415 Cumberland Avenue
Building Renovation: Commercial & Residential
Level III Site Plan and Subdivision Plan
2018-011
Applicant: 415 CA, LLC.

Submitted to Portland Planning Board	Prepared by: Christian Roadman
Public Hearing Date: April 24, 2018	Date: April 20, 2018

EXISTING WINDOWS TO BE REFURBISHED WHERE POSSIBLE, AND WHERE NECESSARY TO BE REPLACED WITH NEW WINDOWS TO MATCH EXISTING (NEW WINDOWS WILL BE DOUBLE GLAZED BUT WILL MATCH IN APPEARANCE)

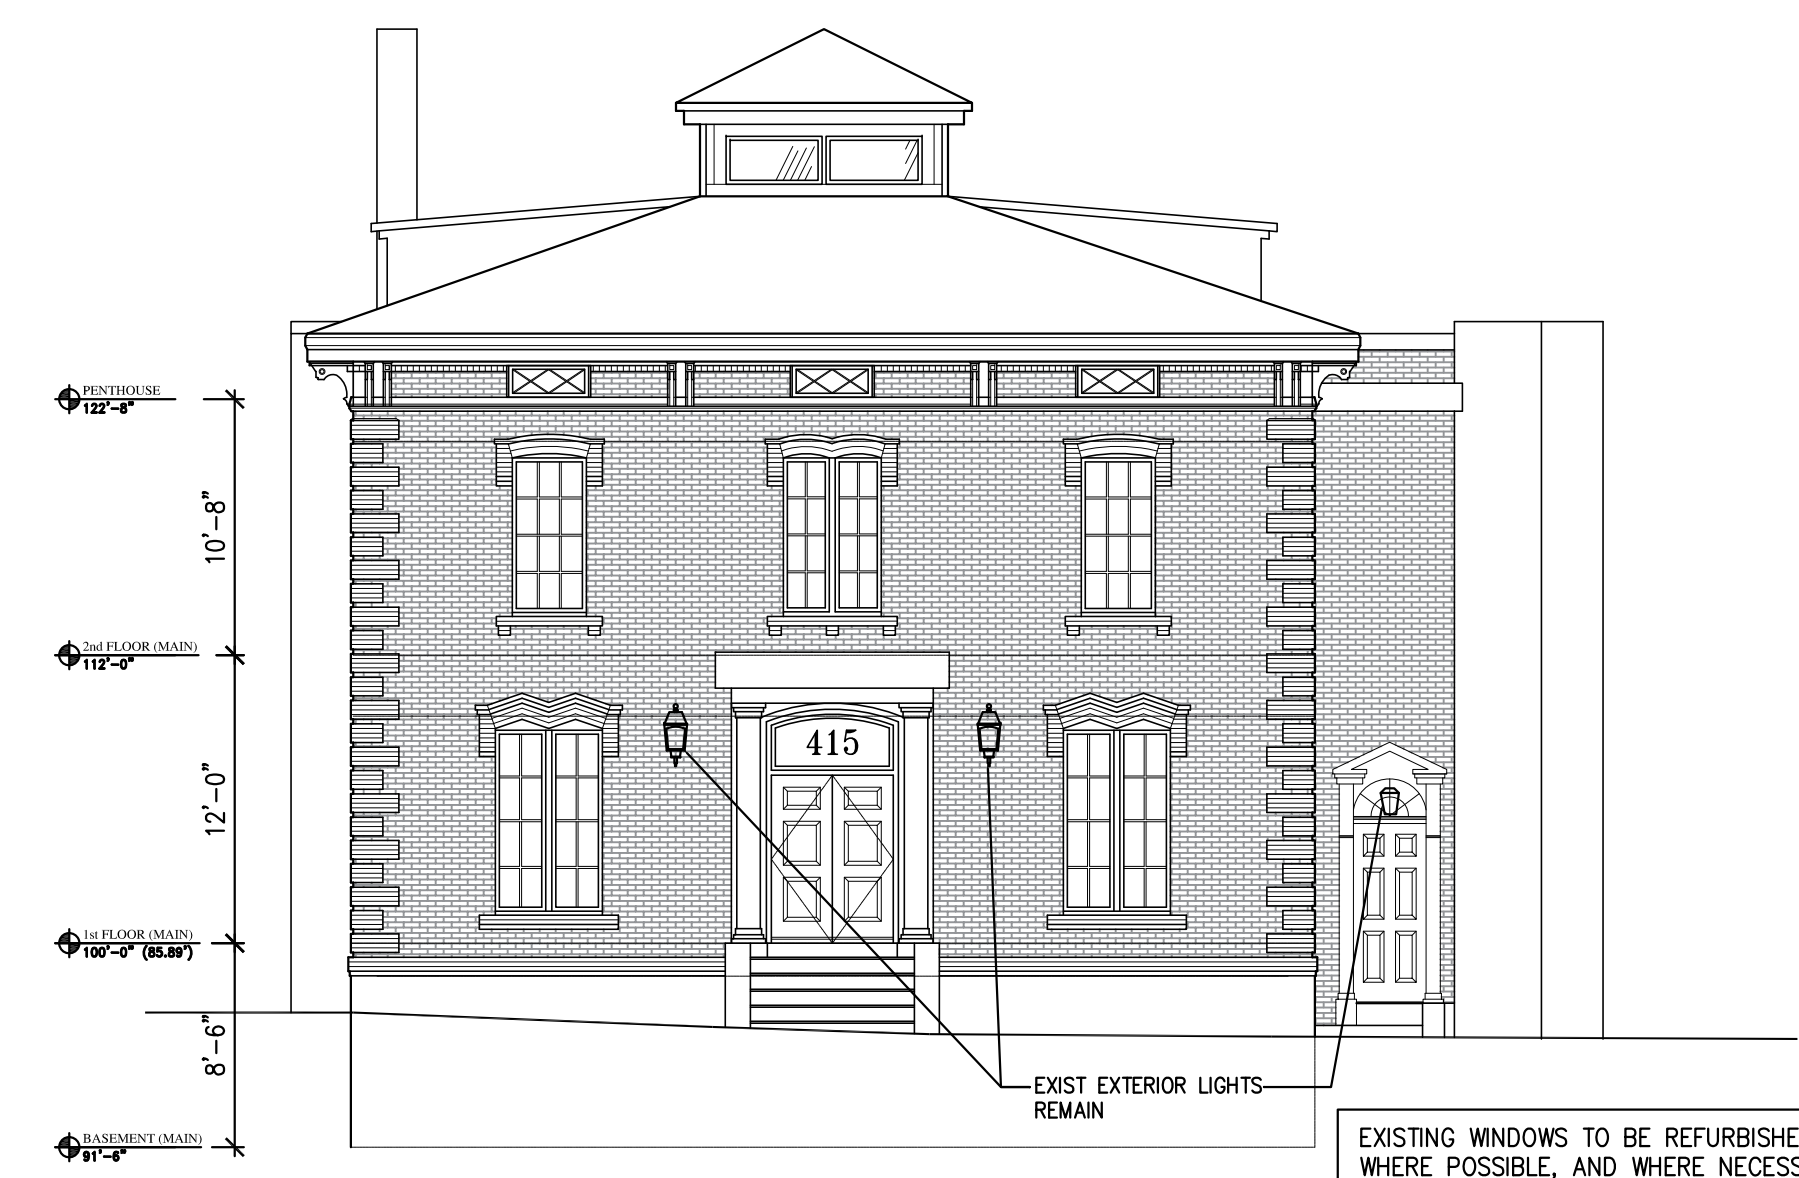
Ms. Andrews commented that new windows should match the existing windows in material, muntin configuration and profile, color, and operation. This is of particular importance on elevations in which new and existing windows will be present.

Additionally, Ms. Andrews requested a detail of the metal canopy proposed over the Forest Avenue entrance. Proposed window details, as well as the proposed metal canopy detail, should be submitted for review and approval by Ms. Andrews as a condition of approval.

- 1. Proposed window specifications and the proposed metal canopy detail shall be submitted for review and approval by historic preservation staff.
- 2. The applicant shall submit additional information pertaining to construction management, including: Pedestrian detour plan minimizing sidewalk impact; construction material delivery and truck plan minimizing sidewalk and vehicle lane impact; and, information on contractor parking such that public on-street parking is not impacted.

Sheet Title:	<b>SITE PLAN</b>
--------------	------------------

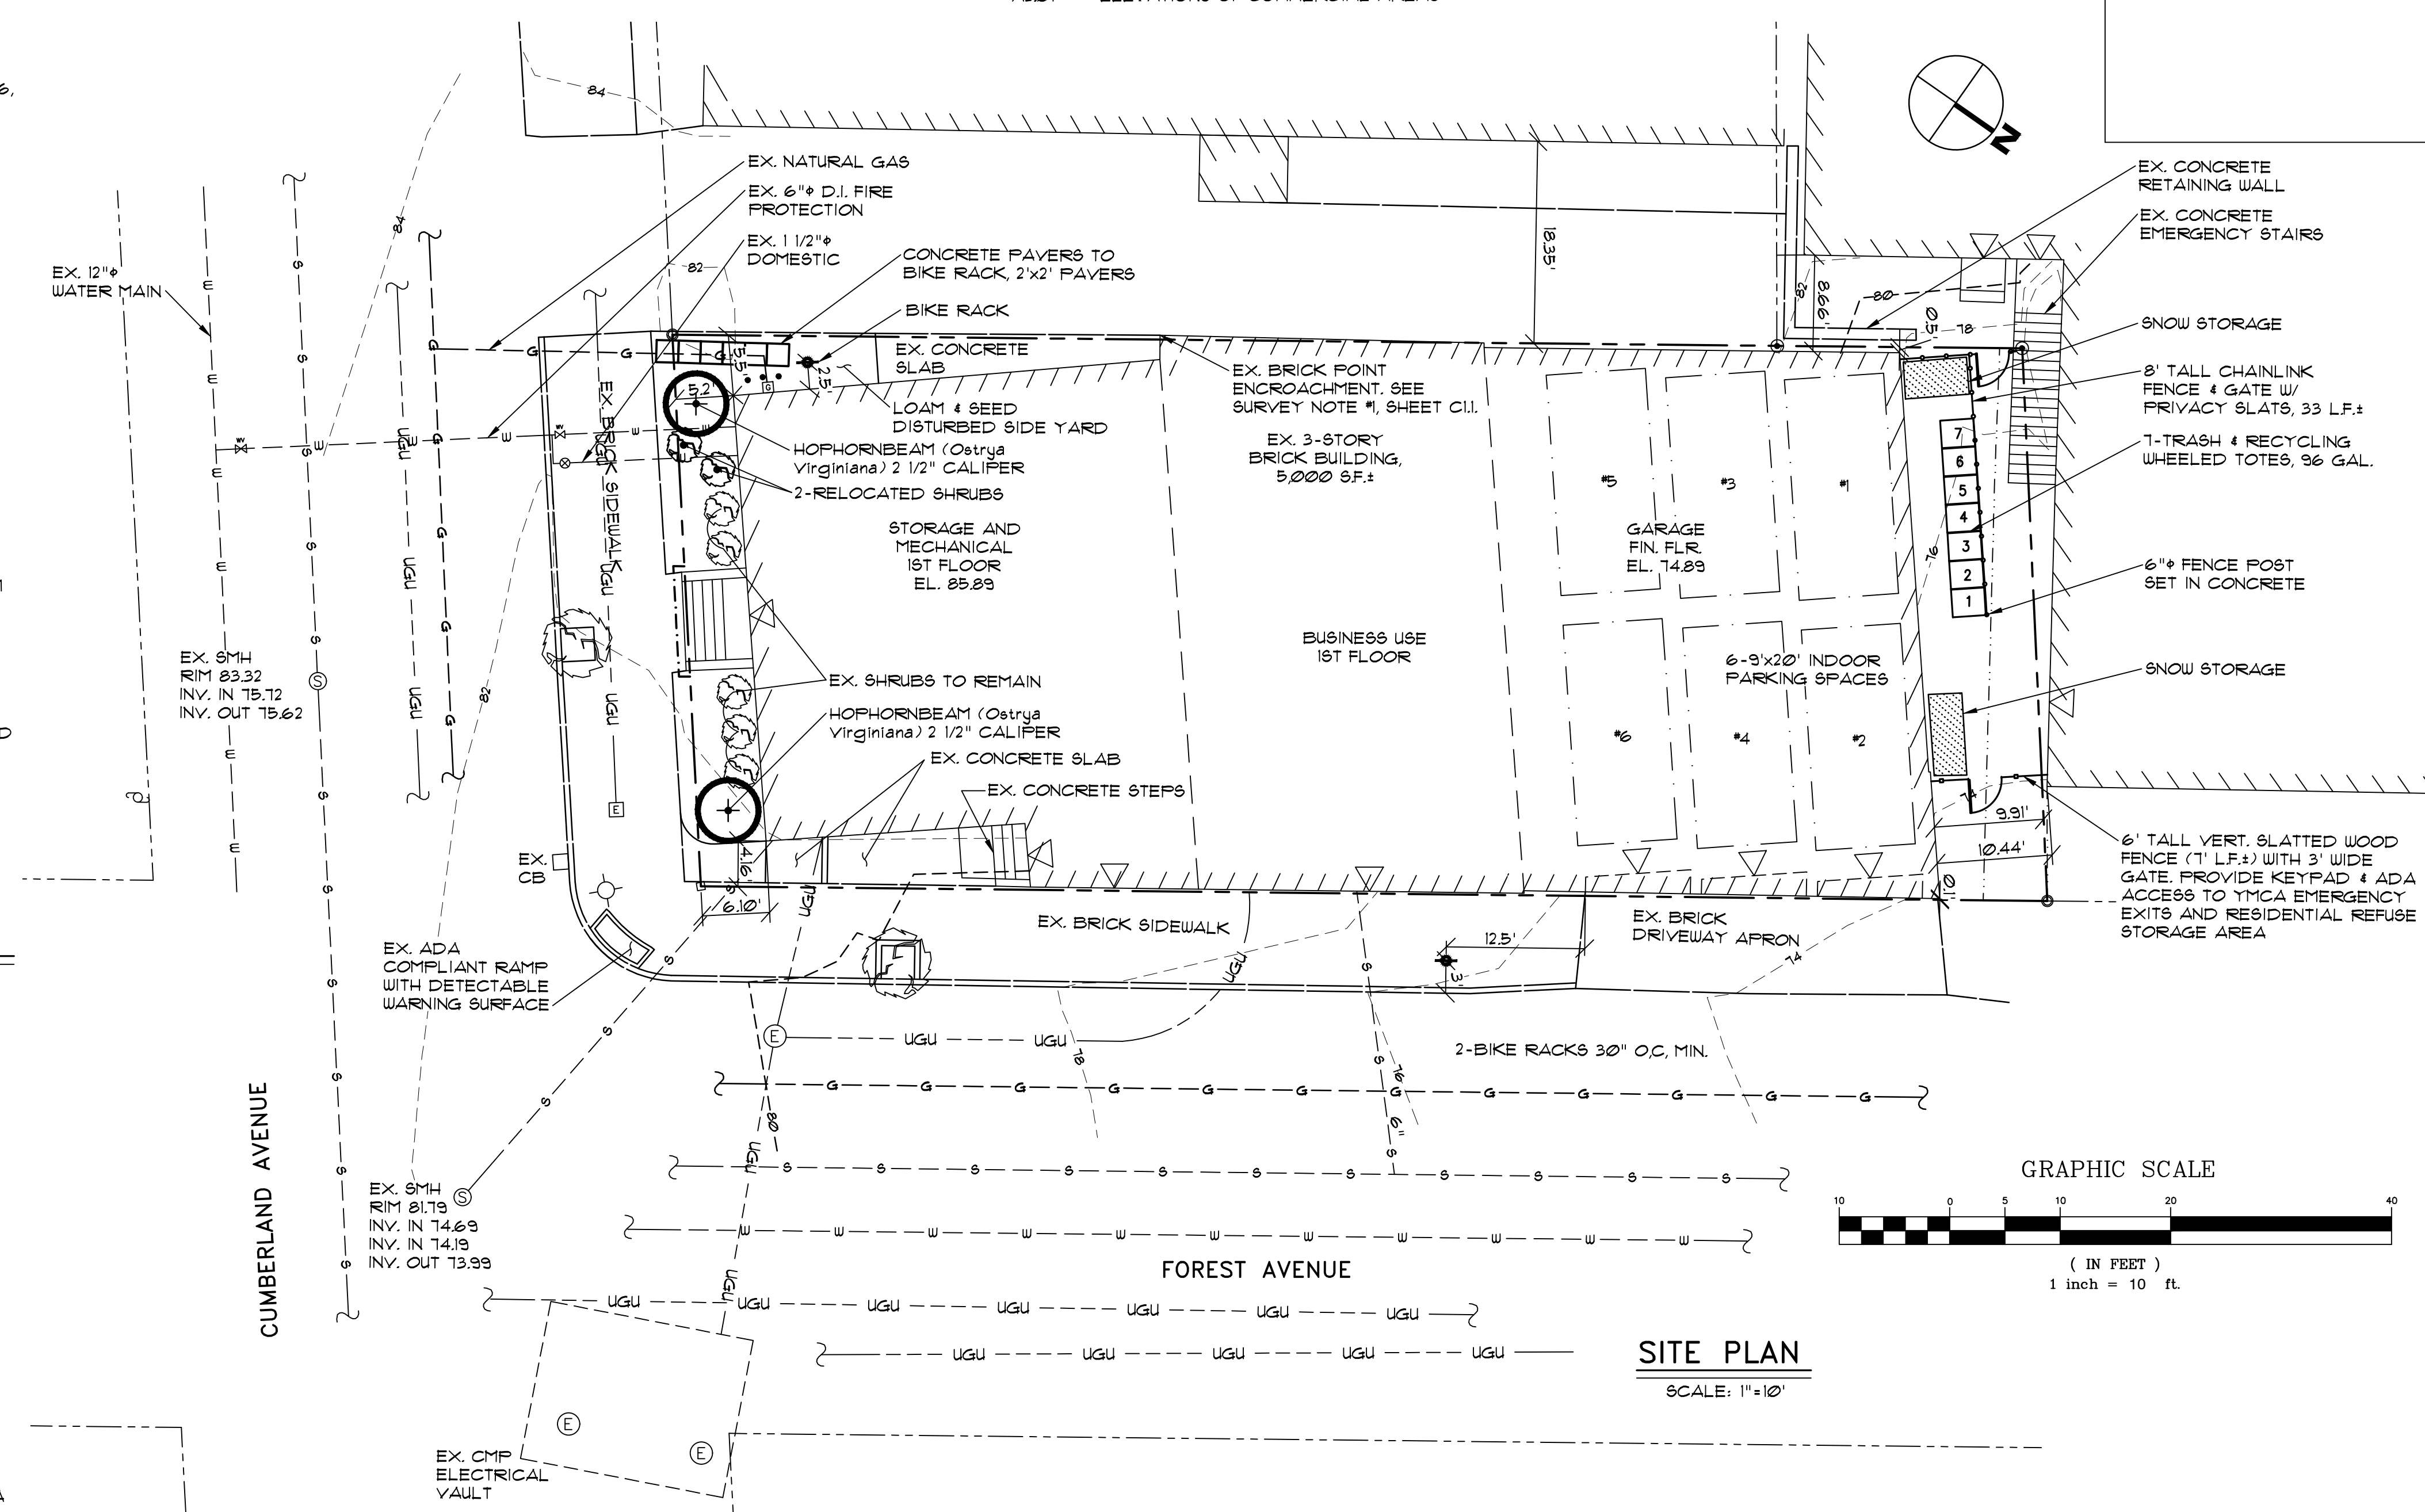
Bruce Hyman, the City's transportation program manager, expressed concern regarding the condition and grade of the sidewalk and driveway along Forest Avenue. As a condition of approval, existing and proposed grades shall be submitted for review and approval by the Planning Authority.

Because the project proposes eight residential units, four street trees required under the City's Technical Standards are required. Applicant payment of the fee-in-lieu for four street trees is suggested as a condition of approval.

- 3. Existing and proposed grades of the property's sidewalk and driveway along Forest Avenue shall be submitted for review and approval by the Planning Authority.

- 5. The applicant shall pay into the City's street tree, at a cost of \$400 per tree, to account for each of the four trees not provided per the City's Technical Standards.
